Our Ref: P/19/15/HH

Application for Planning Permission for Works or Extension to a Dwelling

Development Single storey side extension & conservatory.

Location 9 Leonora Drive Pagham

west [leonora drive]

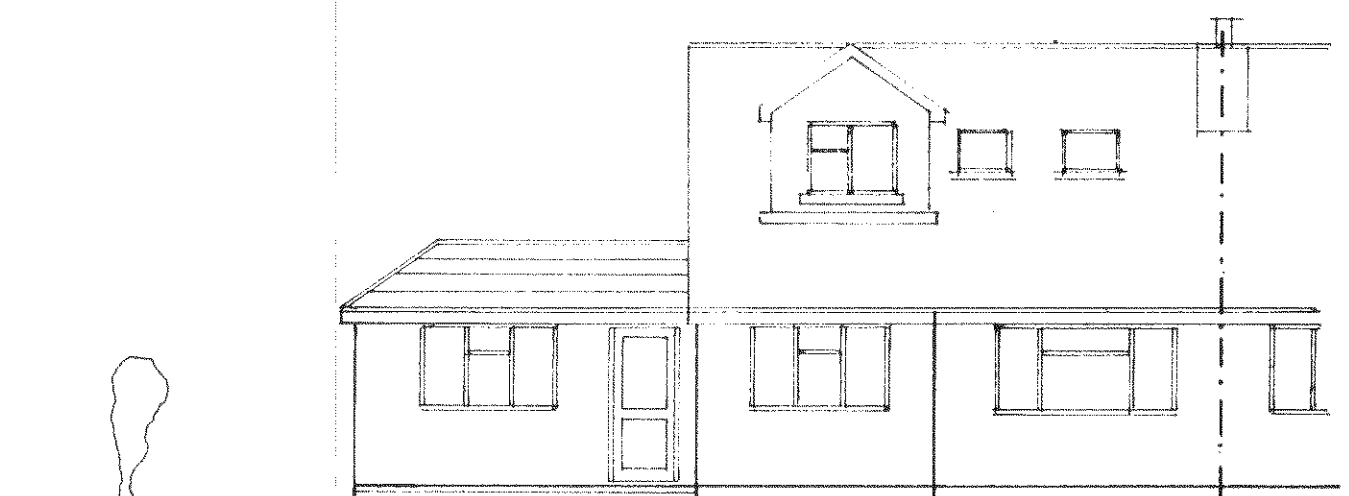
Please confirm if the proposed dormer on the West elevation forms part of the application, if not then please annotate the plans as such.
